SUBJECT: 515 SLATE N.W. (T14)

RE: ADDITIONAL INFORMATION FOR DRAINAGE PLAN  
SUNWEST OPERATIONS CENTER ANNEX, 515 SLATL AVE., N.W., J-14-2

REF: GRADING AND DRAINAGE PLAN FOR SUNWEST BANK OPERATIONS CENTER ANNEX  
(J14-D35) RECEIVED DECEMBER 19, 1983

SITE PLAN & DRAINAGE PLAN

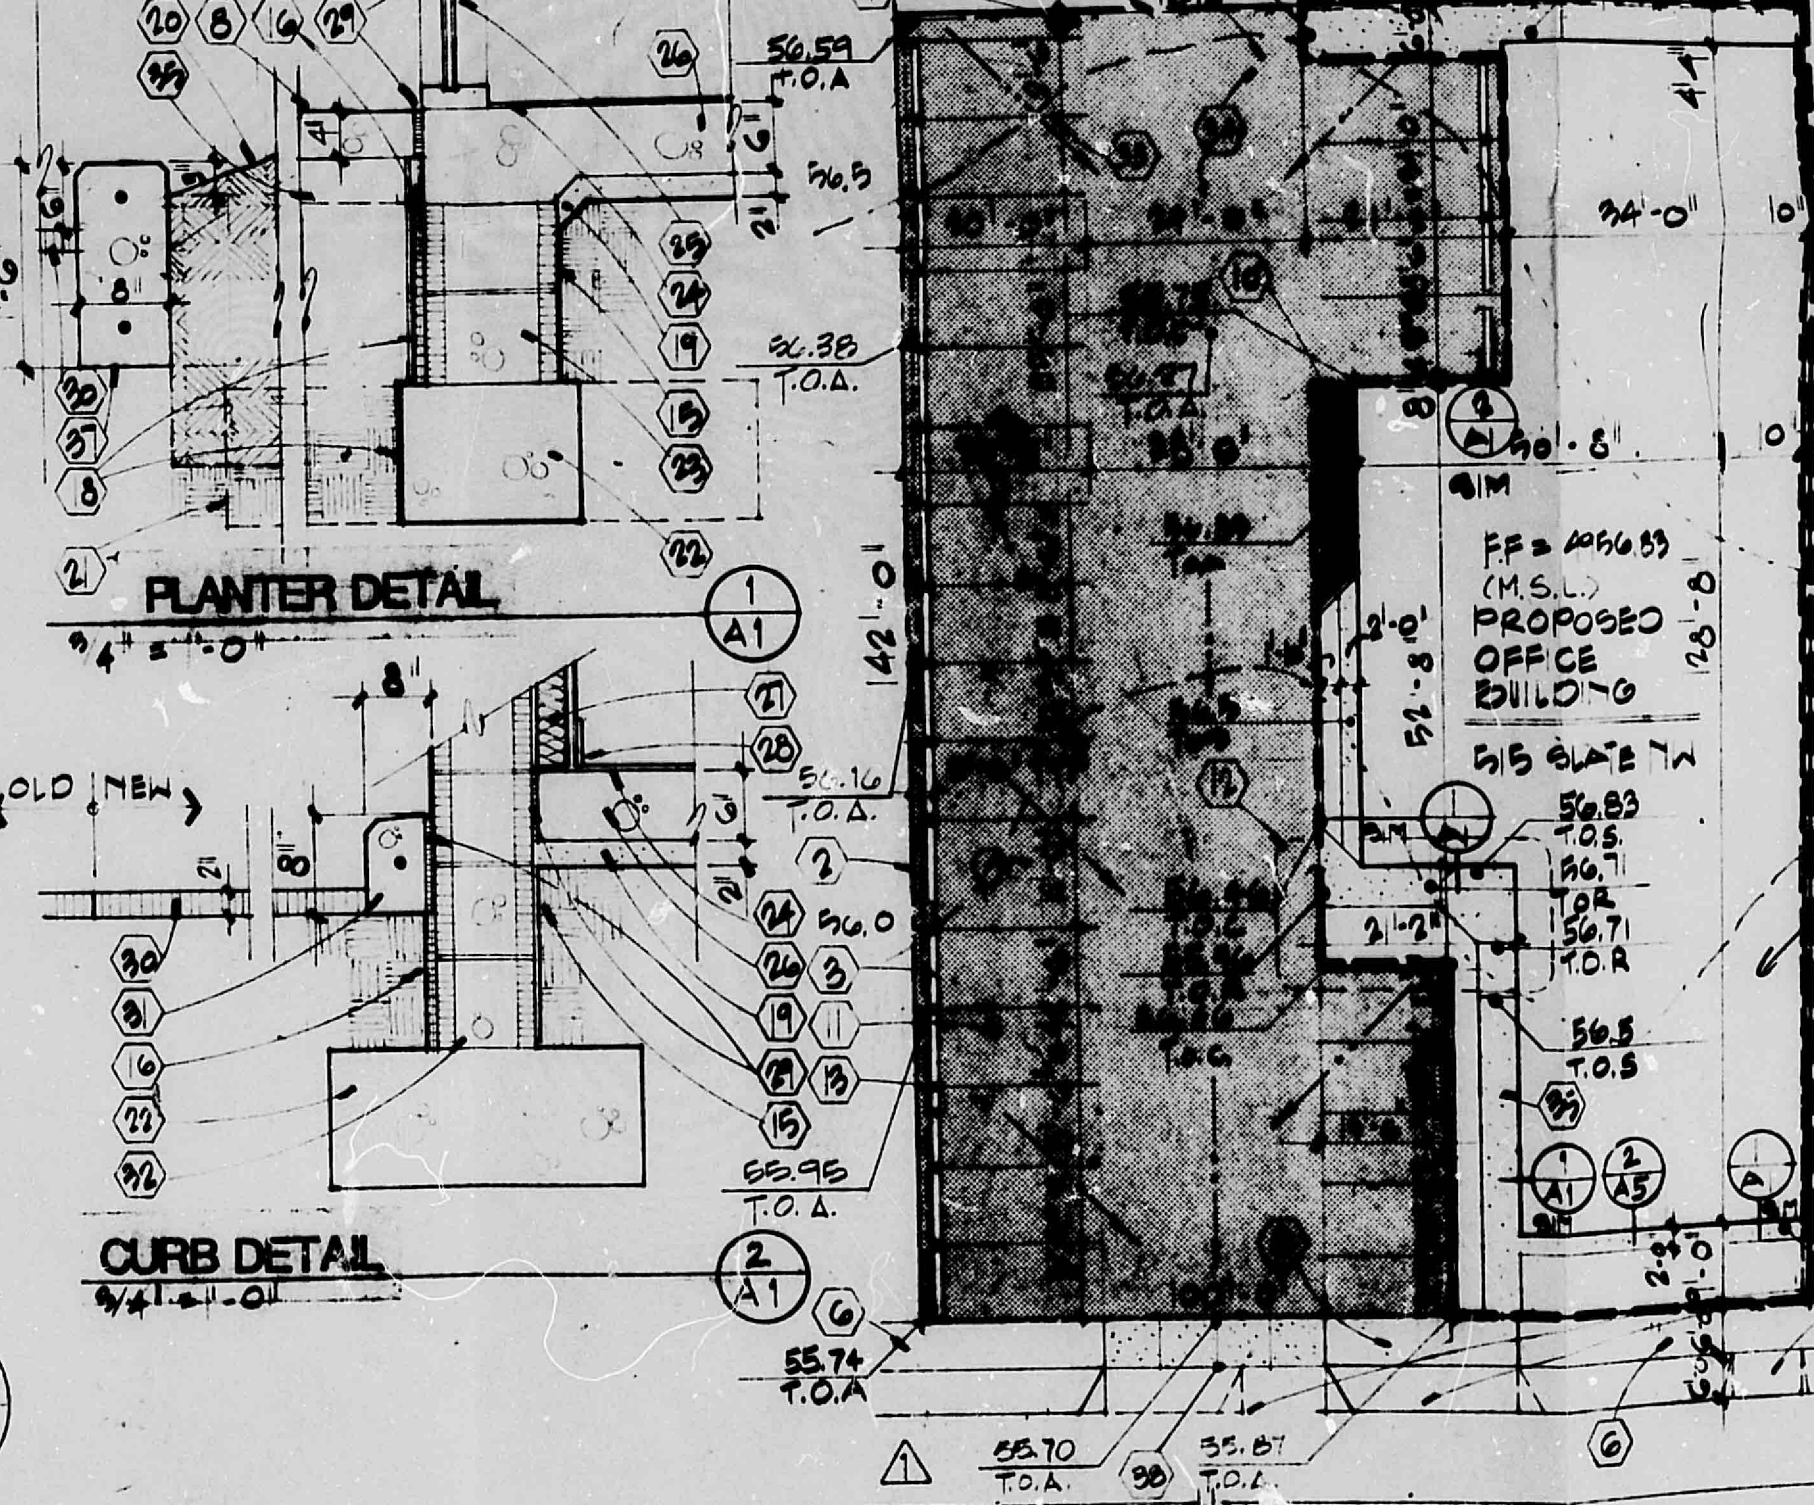
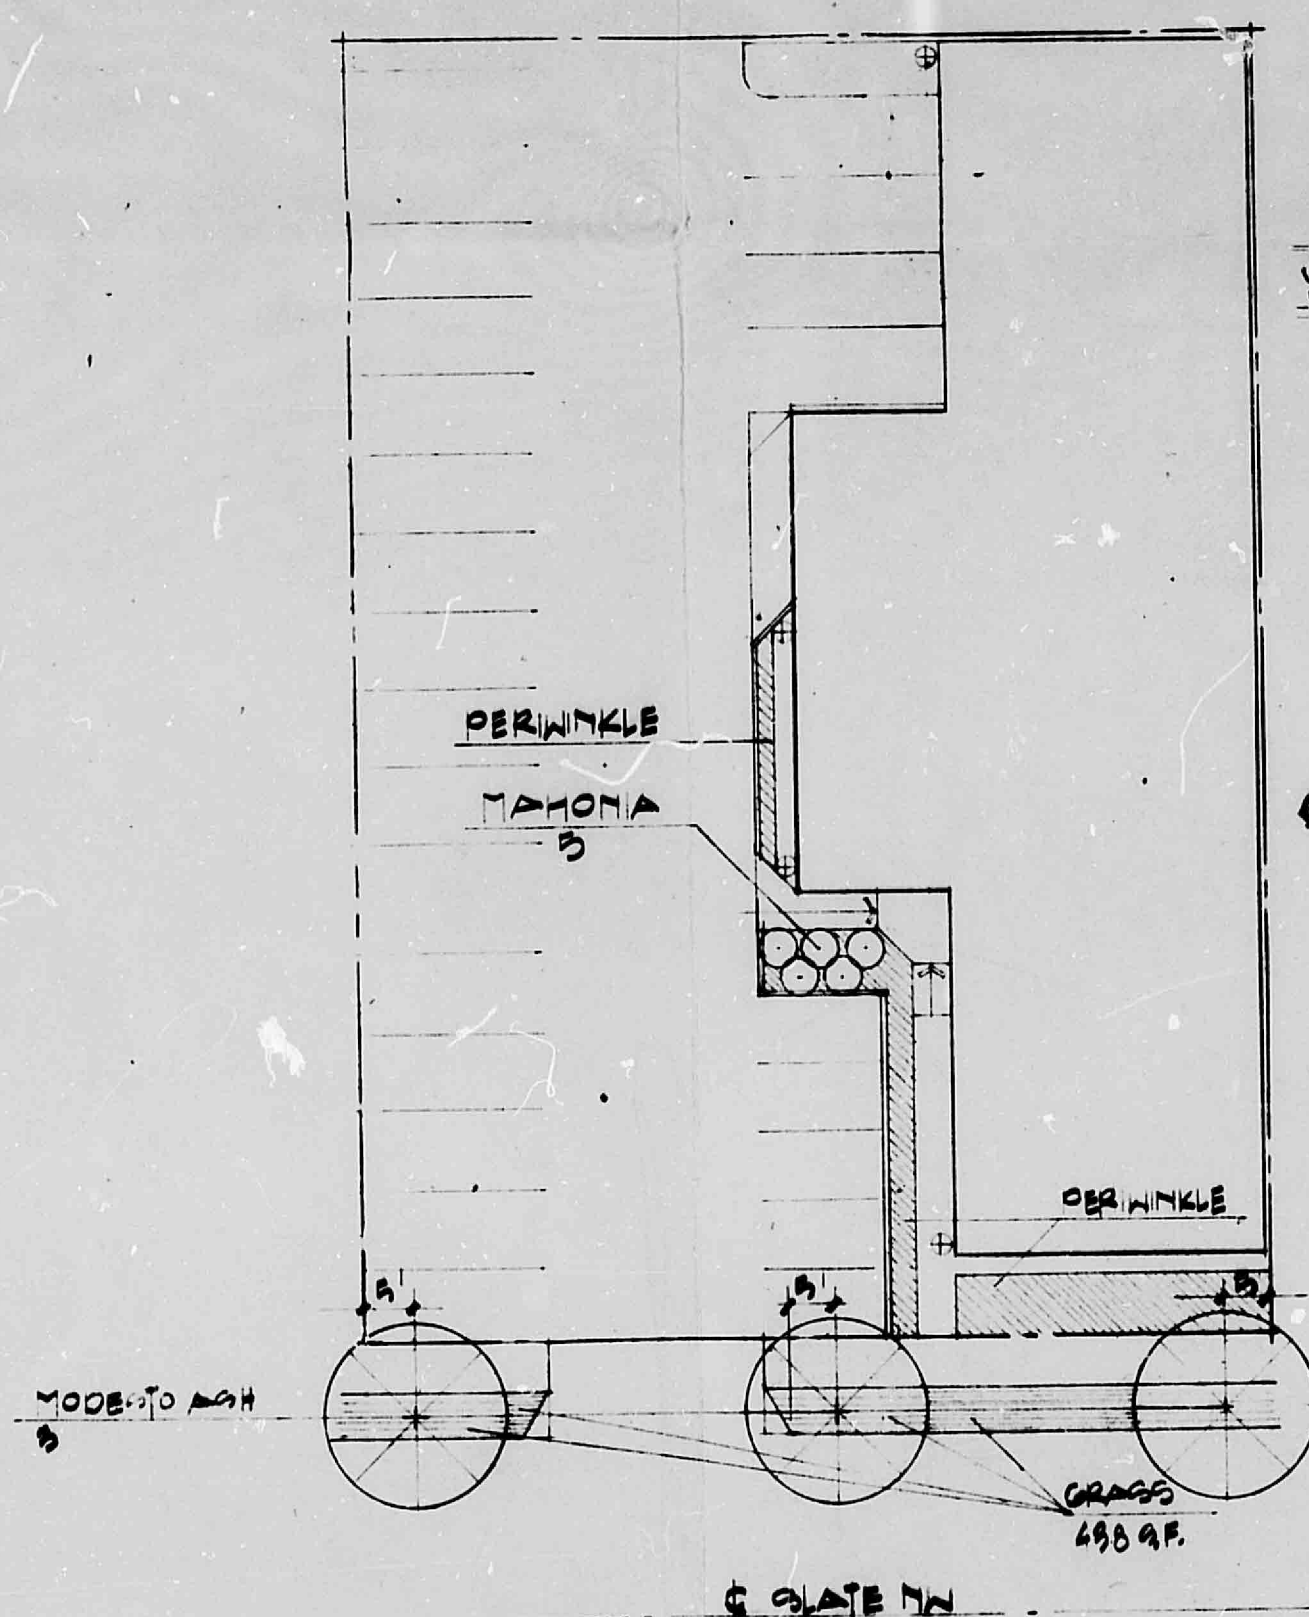
As you requested in our conversation of December 14, 1983, we have added the following information to the above-referenced Drainage Plan dated November 29, 1983. A print of the revised Site Plan and Drainage Plan is attached.

1. Additional spot elevations on the top of asphalt in the existing paved parking area and driveway to supplement the contour elevations already shown.
2. Arrows indicating direction of flow of storm runoff.
3. Limit of pavement removal to clarify keyed Note 11.

The above referenced plan, revised December 16, 1983, is approved.
